Subject: RE: AL/106/19/DOC

Thanks, Environmental Health are satisfied that Condition 10 can be discharged. Just waiting for the expansion of the information if a lighting complaint is received.

Further to my previous response to this application for Condition 7 (CMP), I asked for further detail on their complaint procedure in the CMP should there be a lighting complaint. They have just stated 'in the event of any queries or concerns the site manager is contactable'. Given that we have already had a lighting complaint about this site, I would appreciate it if they could expand more to advise of their complaint procedure in the event of a lighting complaint. I am satisfied with the noise part of the CMP, now they have put more detail into it.

REV. No.	DATE	DESCRIPTION	INITIALS
Client			
Project	Westergate & Eastergate		
Title	External Works Layout Sheet 1	Scale 1:250@A0 Checked AMc	Date Mar '18 Drawn KT
Drawing No.	5655:40	Rev	H

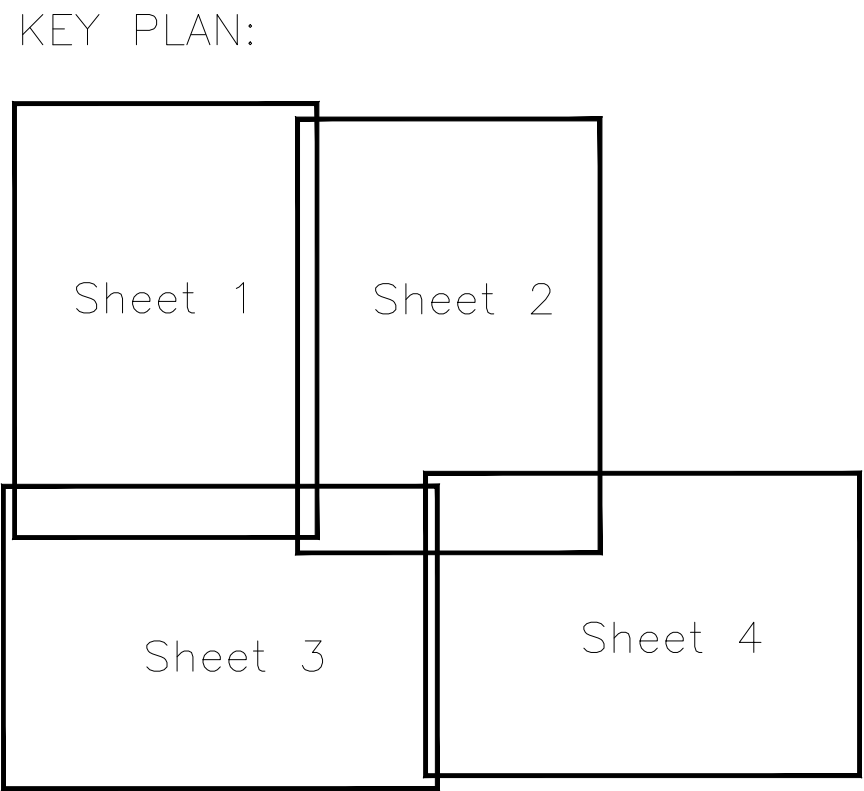
I haven't been able to find confirmation of the fact that the Lighting Schedule complies with Zone E2 of the ILP guidance – as discussed there are a couple of documents that the Planning Portal seems intent to keep me away from! If you could point me to the documentation that contains the Zone E2 confirmation I would be very grateful.
